MINUTES OF THE DEVELOPMENT ASSESSMENT PANEL HELD FRIDAY 18 AUGUST 2006

**Property
Description:** Lot 1 DP 777183, 2 Wharf Street TWEED HEADS NSW 2485

Proposal: Partial Demolition of Twin Towns Services Club and New Additions

## PROPOSED CARPARKING ARRANGEMENT

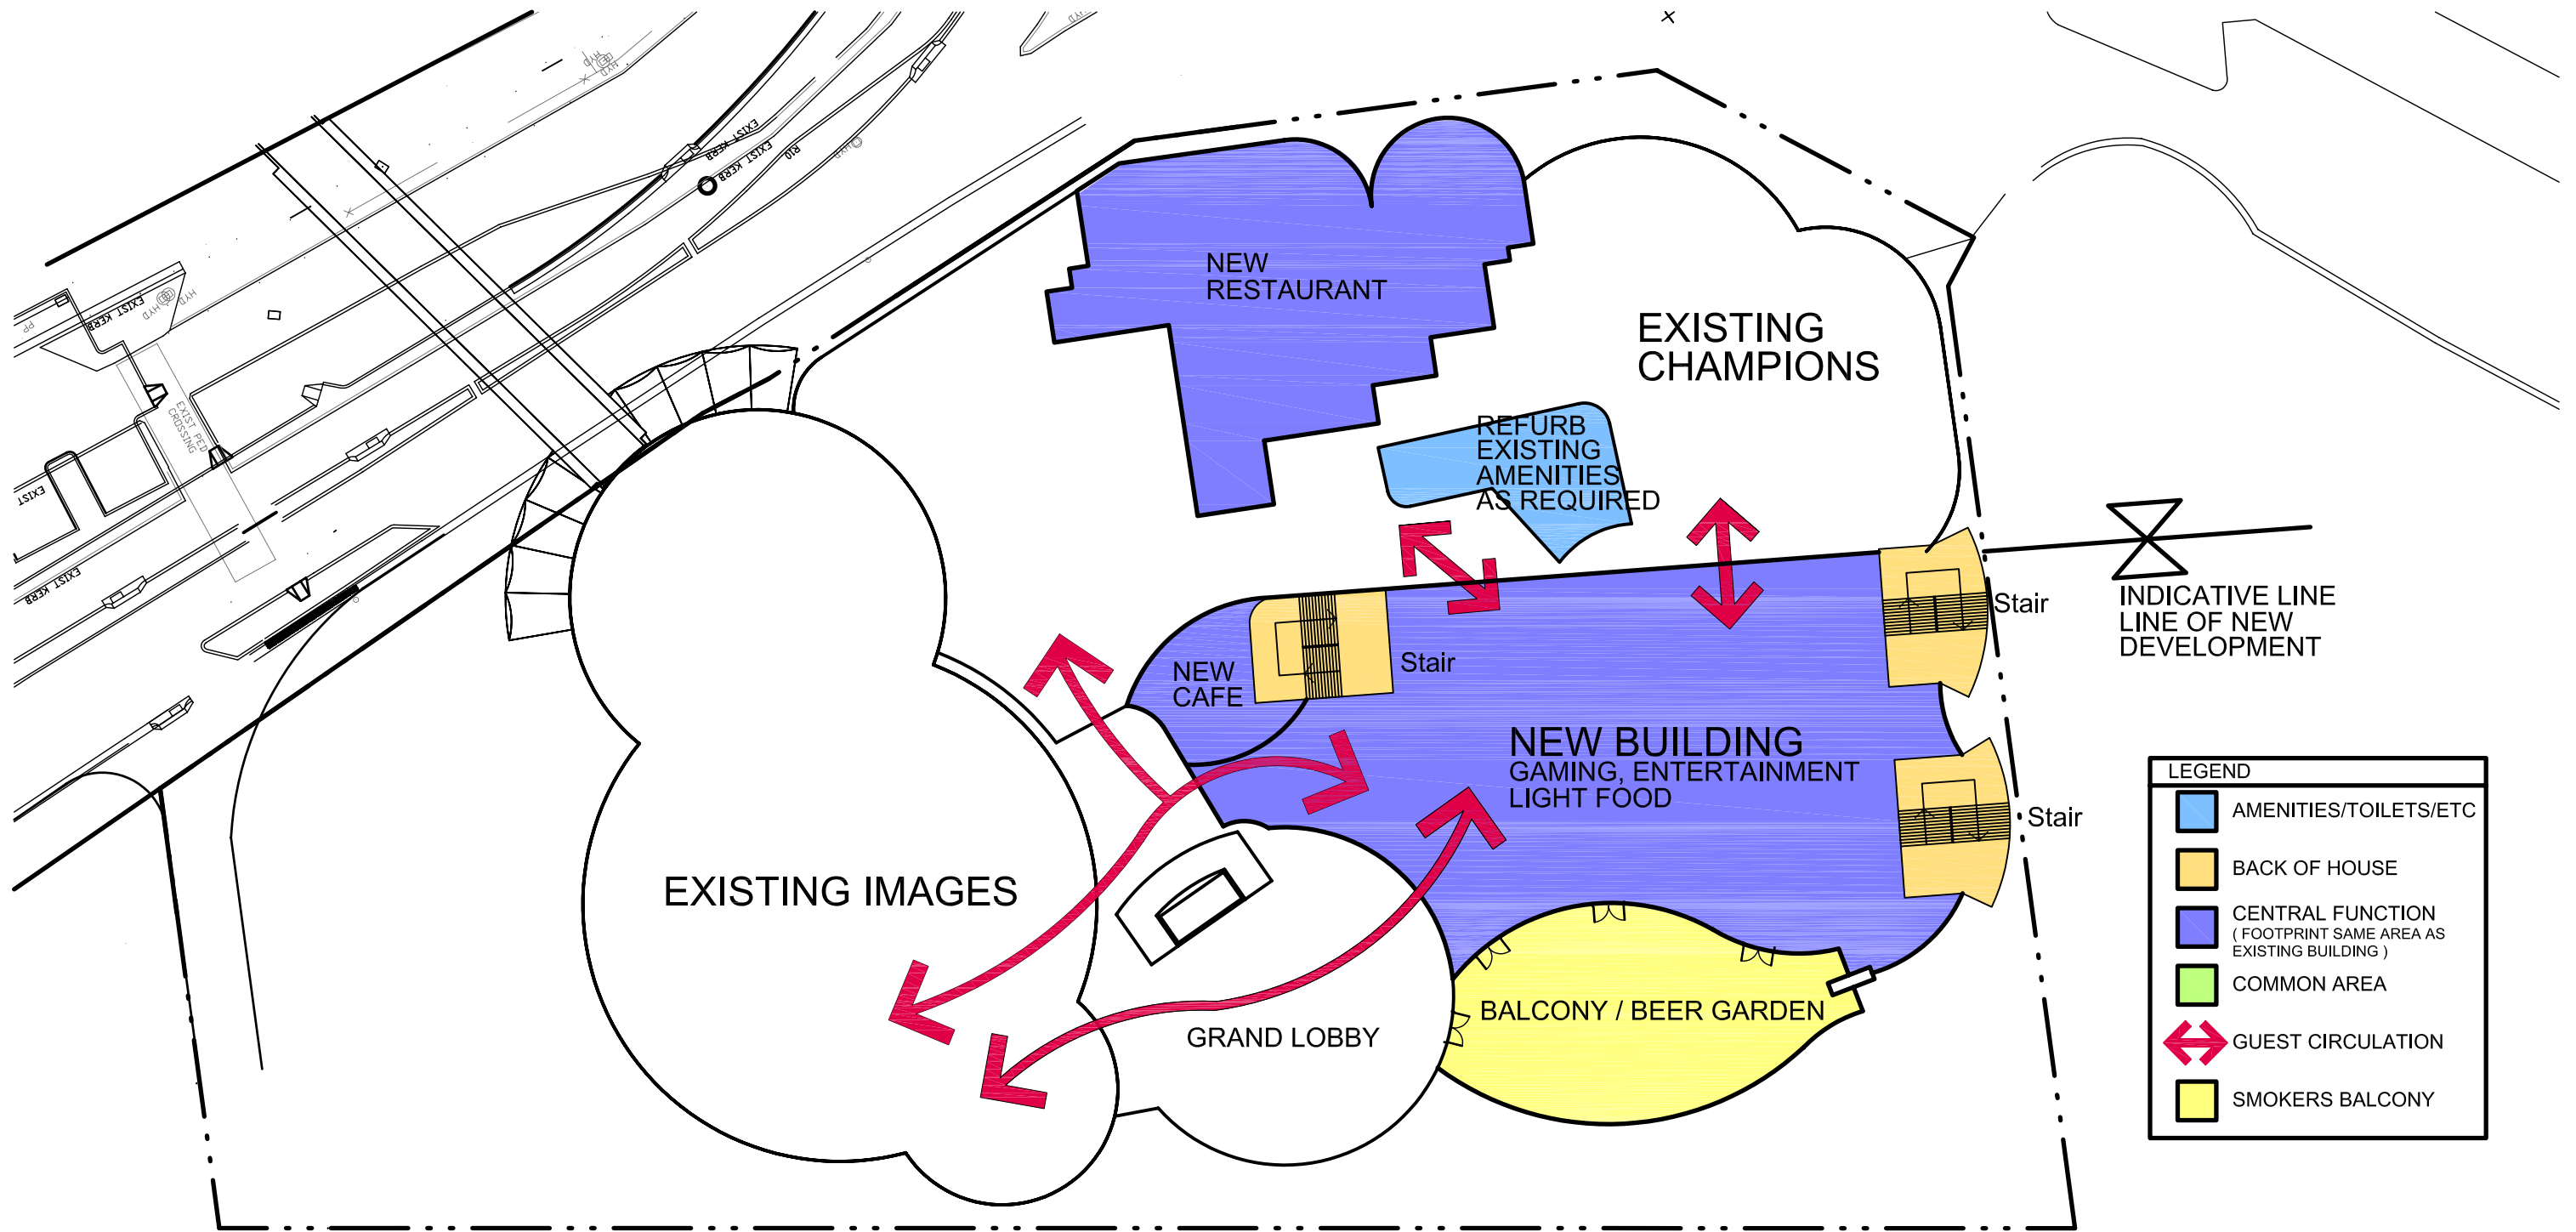
- Carparking – The provisions of Carparking would need to comply with DCP 2 - Site Access & Car Parking Code. The applicants have indicated that the carparking demand study will be provided with the application justifying the proposed carparking and any variations to the DCP.

WATERFRONT ELEVATION

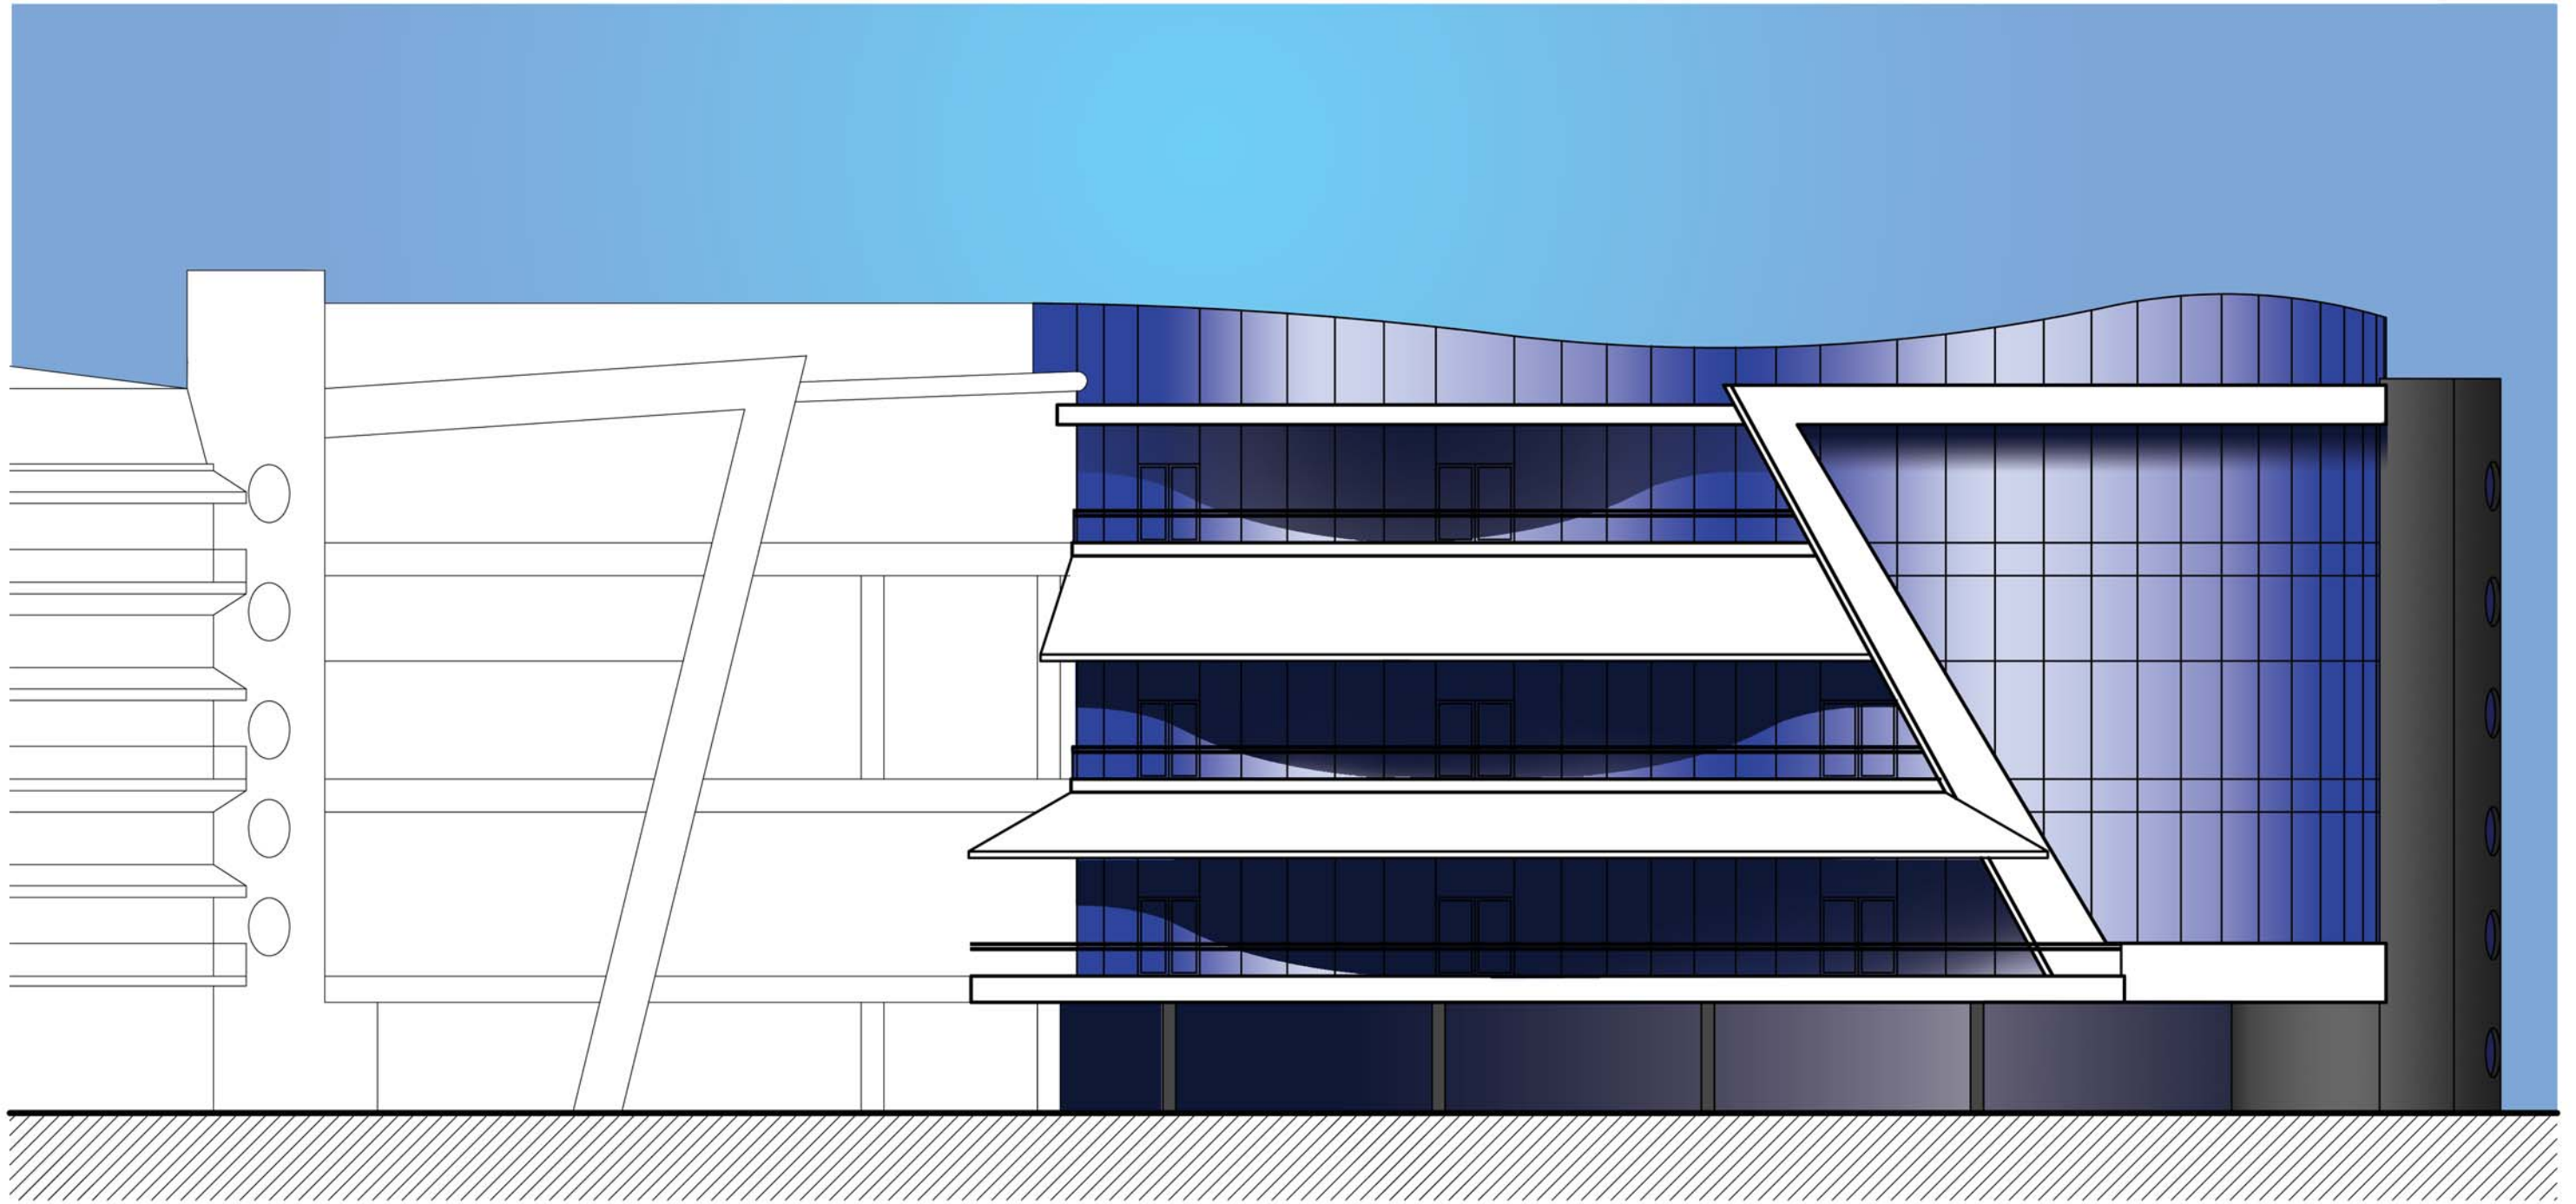
- Tweed Heads Master Plan – The provisions of the Tweed Heads Master Plan must be addressed in the application particularly the Jack Evans Boat Harbour interface requirements of the plan. Additionally the nominated height of the site

TWIN TOWNS SERVICES CLUB	
BUILDINGS SHADOWS - WINTER SOLSTICE 21 JUNE	
TWIN TOWNS WATERFRONT REDEVELOPMENT

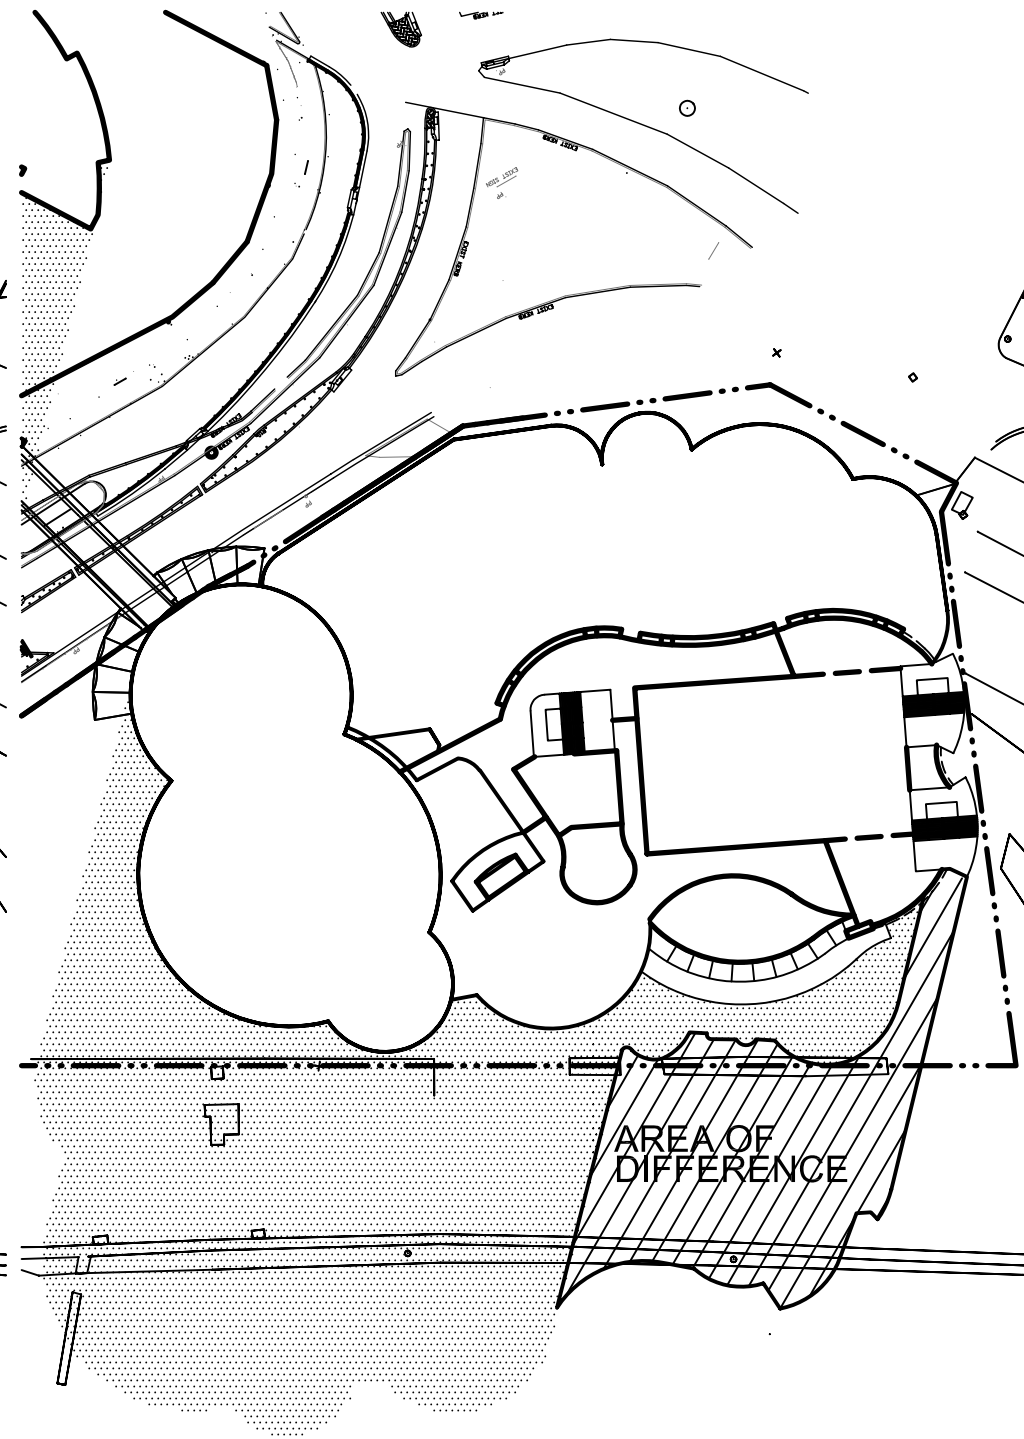
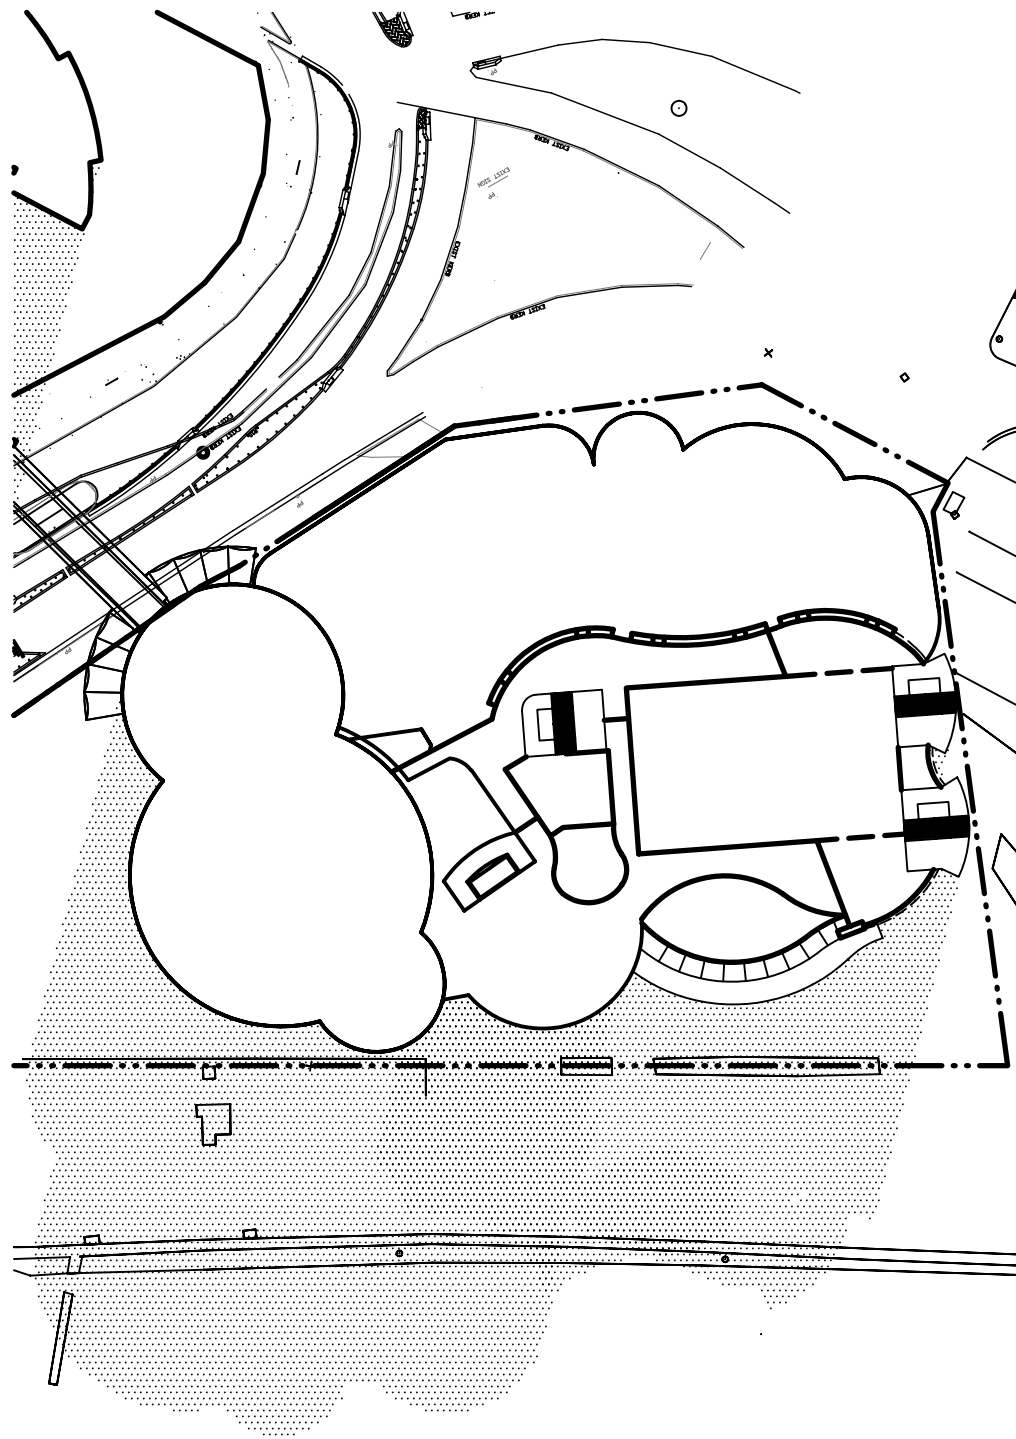
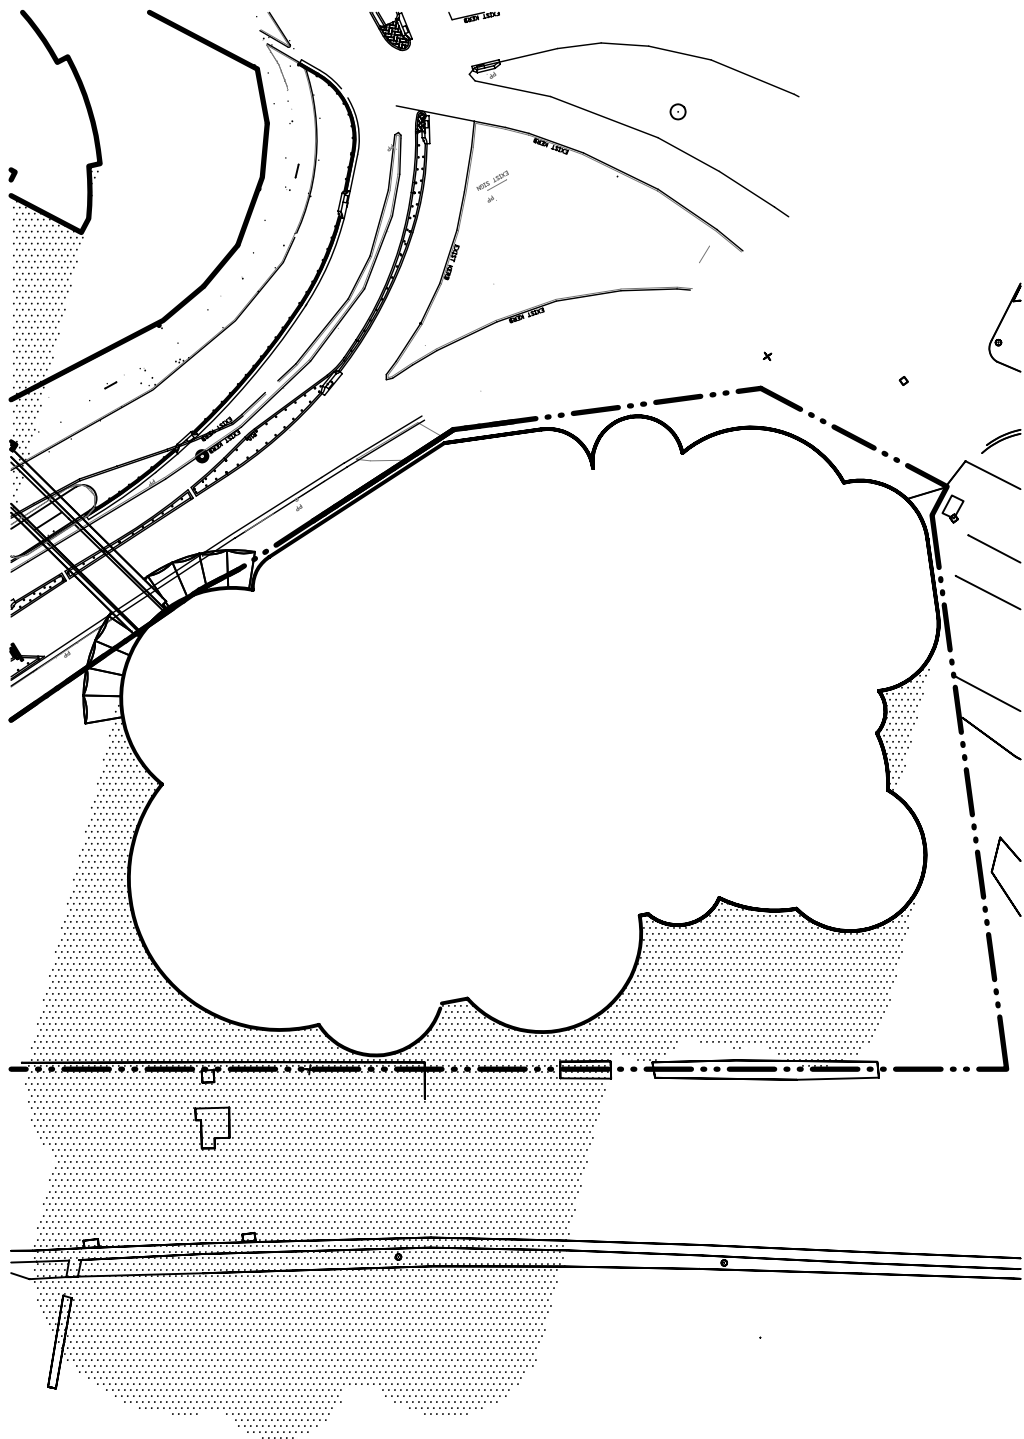
- SEPP1 – An objection under the provisions of SEPP 1 are required to accompany the application regarding the North Coast REP requirements for Foreshore overshadowing. In this regard the endorsed Jack Evans boat Harbour concept design by Tweed Shire Council is to be considered in the objection.
